Longfield Solar Energy Farm Limited

Our Ref: EN010118

### **Application by Longfield Solar Energy Farm Limited for an Order Granting Development Consent for the Longfield Solar Farm Project**

#### **Request for further information**

33kV Cable Trench Sections

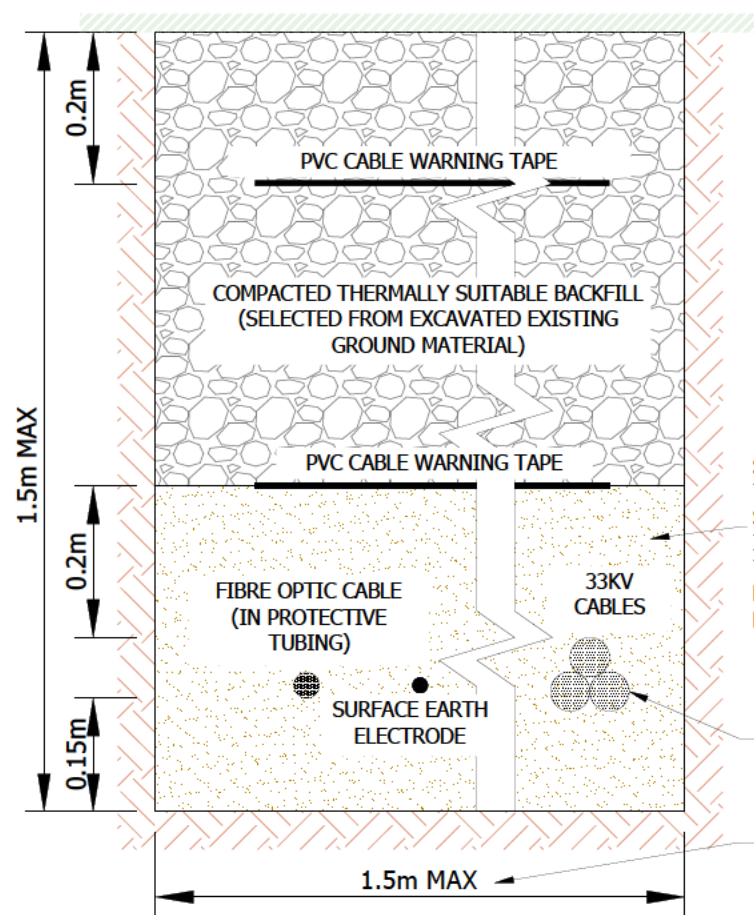
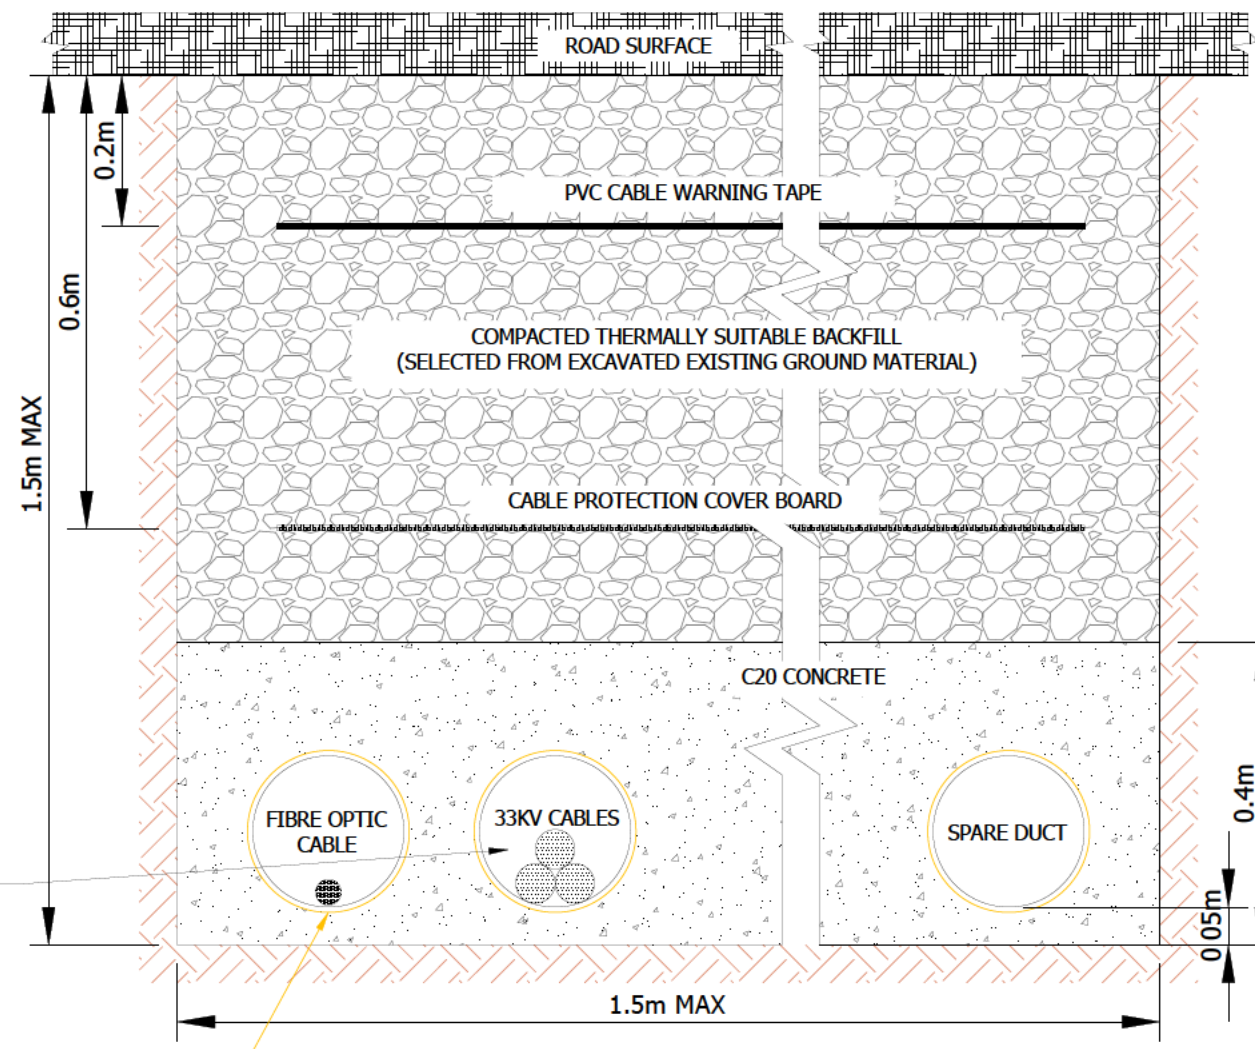
***However, in the case of Work No.4 (grid connection route), the cable trench is defined in the Concept Design [REP6-005] as being 1900mm, whilst in the Outline Design Principles [REP6-007] it is stated as up to 3m wide. ES Chapter 8 (paragraph 8.3.4, a-d) does not specifically refer to the cable route in justifying why construction of the Proposed Development would not result in a greater impact to ecological receptors than the Concept Design. Please explain how this is accounted for in the ecological assessment and why this could not result in a greater adverse impact than what has been assessed.***

***On the basis of the above, I am considering whether provisions should be included in the dDCO to restrict the cable trench width parameter to what has been assessed in the ES. The Applicant is invited to comment.***
